From: frederickelder@aol.com
To: [Gomez, Angela L.; salnarayan@yahoo.com; Lynn Handing; bcowham@comcast.net; schena2@aol.com; vidoo@hotmail.com; laurajane0125@gmail.com; Mike Grandjean; Bryan Handing](mailto:Gomez_Angela_L.;salnarayan@yahoo.com;Lynn_Handing;bcowham@comcast.net;schena2@aol.com;vidoo@hotmail.com;laurajane0125@gmail.com;Mike_Grandjean;Bryan_Handing)
Cc: [Wolfley, Jolene; Rodenbeck, Jay B.](mailto:Wolfley,Jolene;Rodenbeck,Jay.B.)
Subject: Re: DHO January 10th Comments for: PR-2023-006568 (Request for Rehearing)
Date: Monday, January 15, 2024 12:00:05 PM

Dear Neighbors, -- For those of you who were unable to attend it, I wanted to give you a summary of my thoughts on the Albuquerque Development Board hearing from January 10, 2024, regarding the development of the lot at 9200 Wilshire. Overall, it is my opinion that the meeting could best be described as tense. The developers made it clear that the delays caused by these hearings were unprecedented and had already caused them grievous financial harm. On the other hand, the representatives of the various departments from the City of Albuquerque seemed to be more sympathetic to the problems that the development of this lo

CITY OF ALBUQUERQUE
PUBLIC WORKS DEPARTMENT
ENGINEERING DEVELOPMENT GROUP
WILSHIRE PLACE SUBDIVISION
GRADING AND DRAINAGE
GRADING PLAN

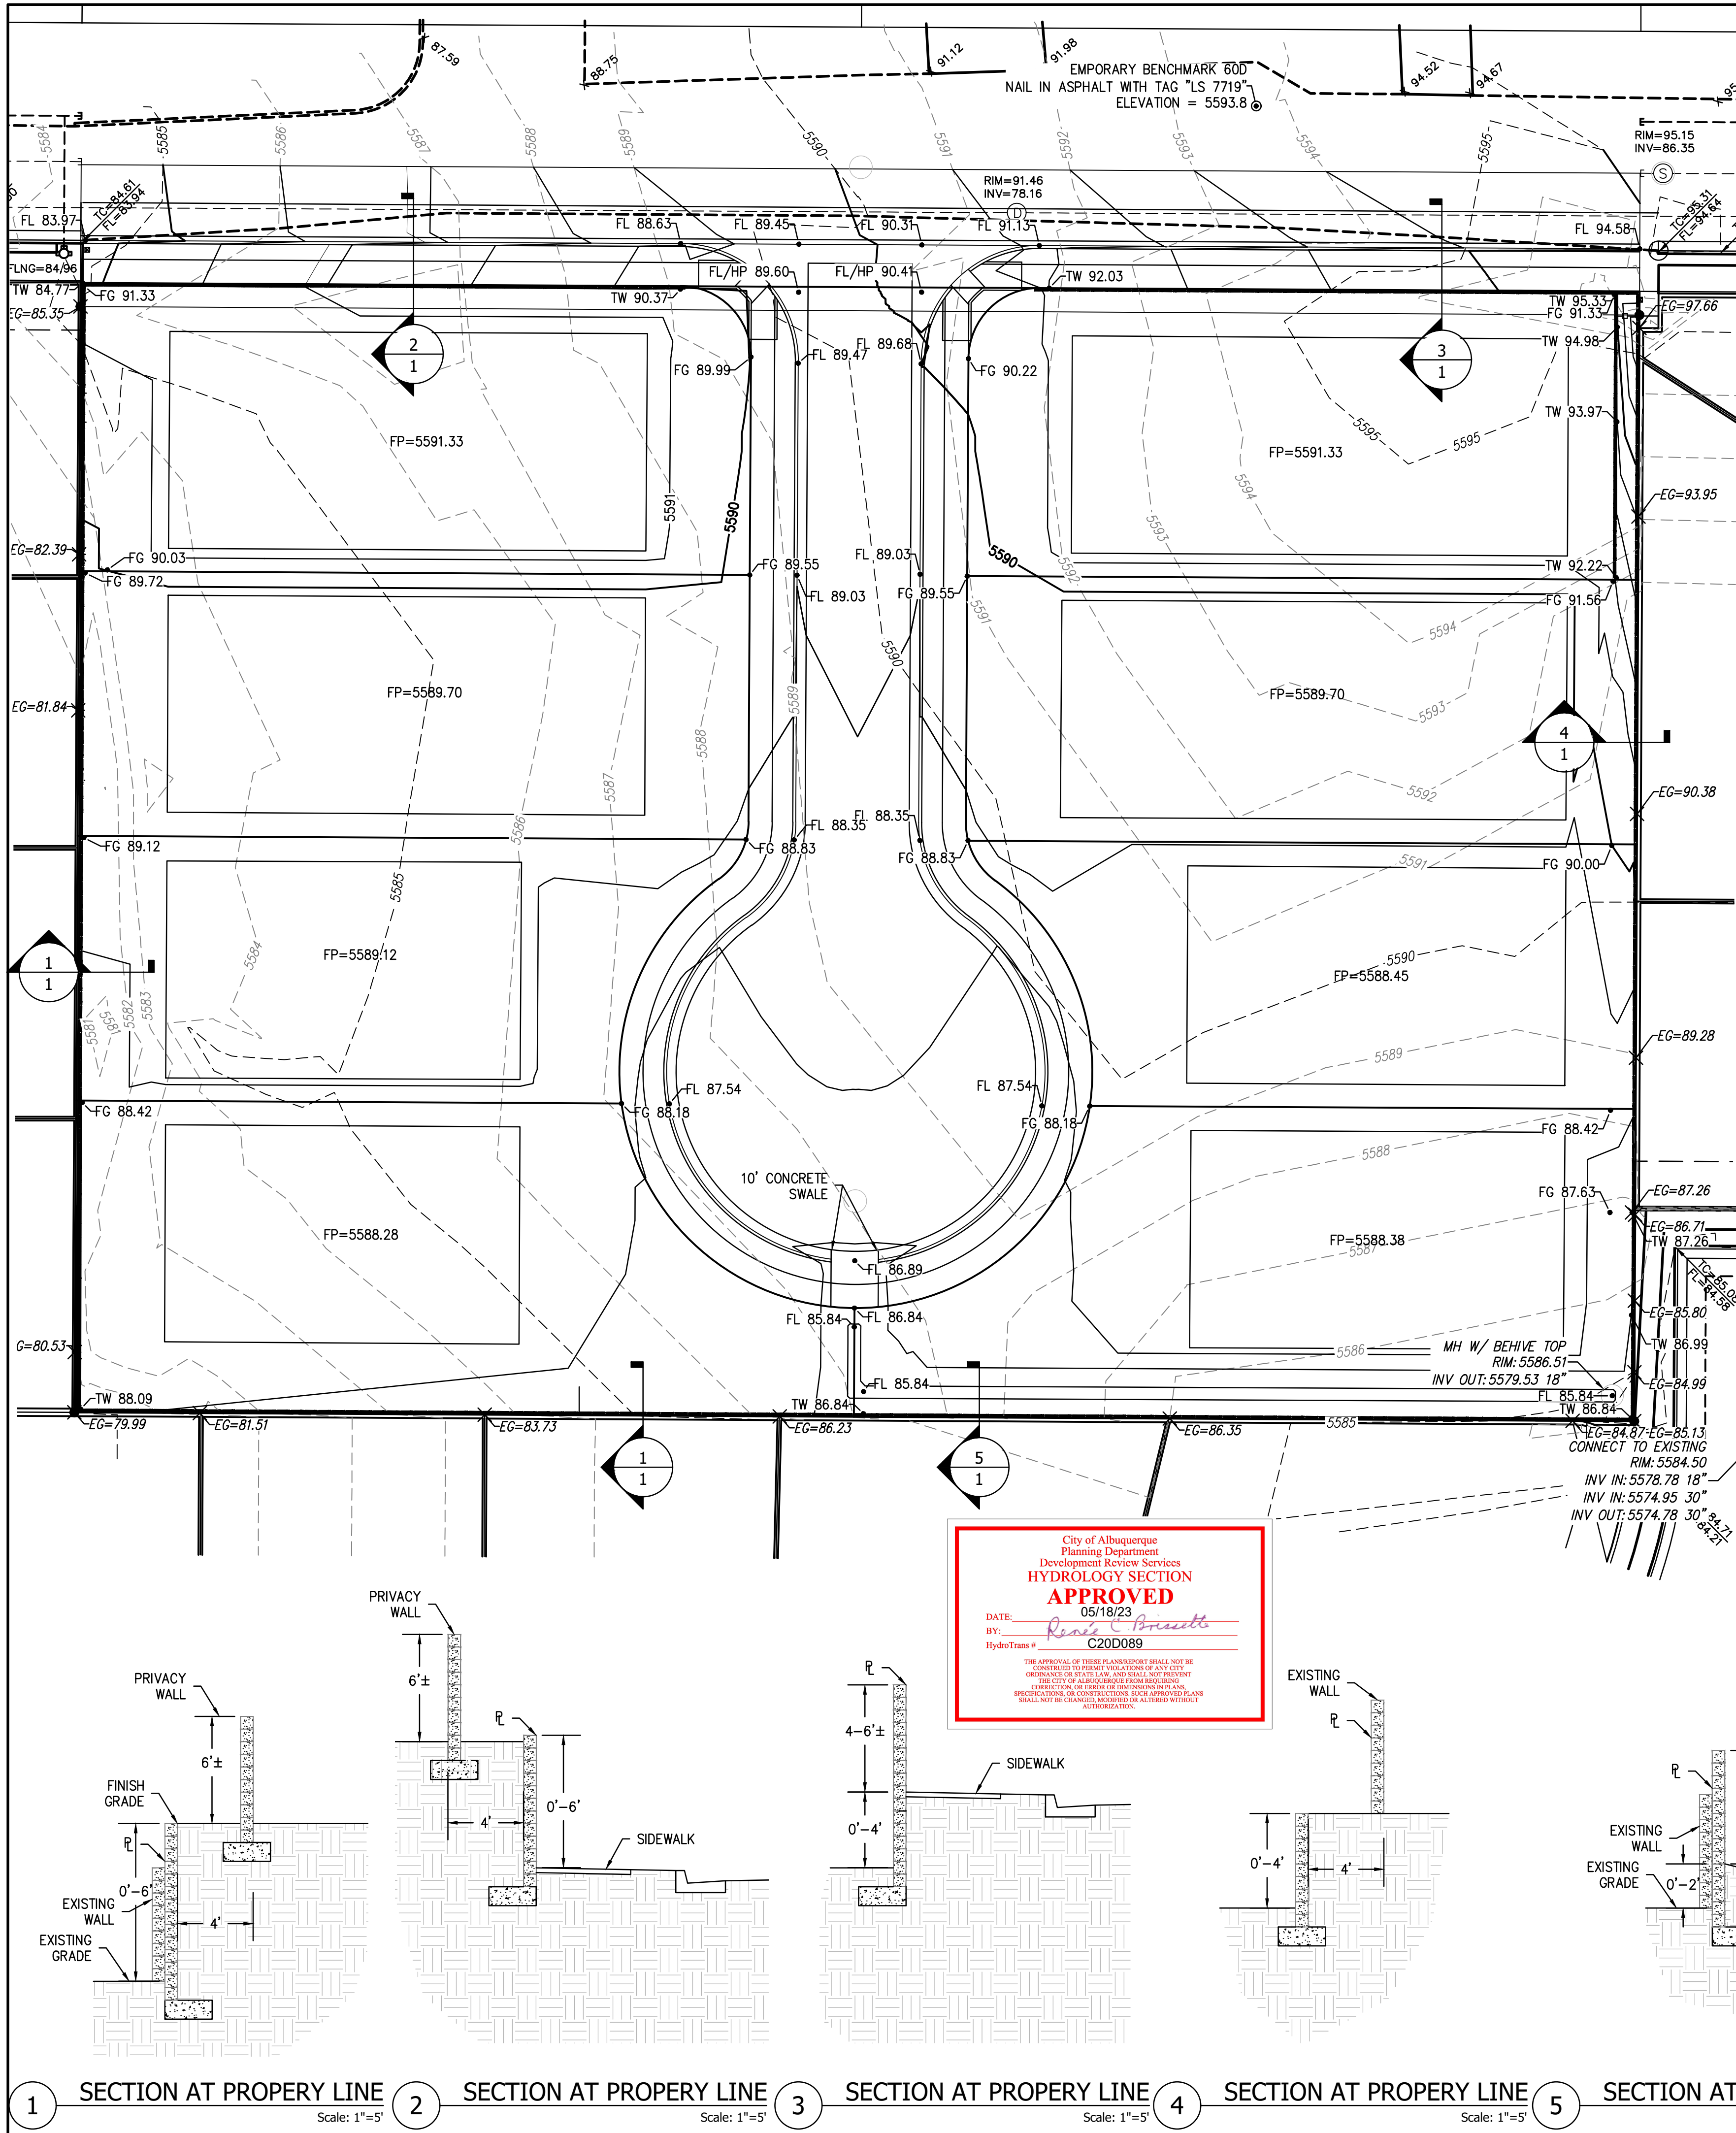
I remain concerned about the original plan as proposed. In particular regarding the height of the fill, the retaining wall height, the easement, and privacy walls for the new development. The proposed fill will elevate the lot to a height of approximately 3 ft higher than my current back wall and approximately 6 ft higher than my ground level. The easement is a significant and worrisome unknown. As proposed, there will be nothing between the easement and my

backyard but a 6 ft drop. If the easement is not protected in some way to prevent intruders, then there will be open access to the houses along Wilshire Ct NE and Corona Ave NE as well as those in the new development. If it is not in the jurisdiction of the new development to maintain the easement, it will likely fall to the residents along Wilshire Ct NE and Corona Ave NE to maintain it and to prevent it from becoming an eyesore for the properties involved. The residents of the new development will likely not even know that it is there. The developers must clearly and precisely address these problems before rather than after construction. If they cannot or will not, then their project needs to be rethought. I am hopeful that the Development Board will support us on this issue.
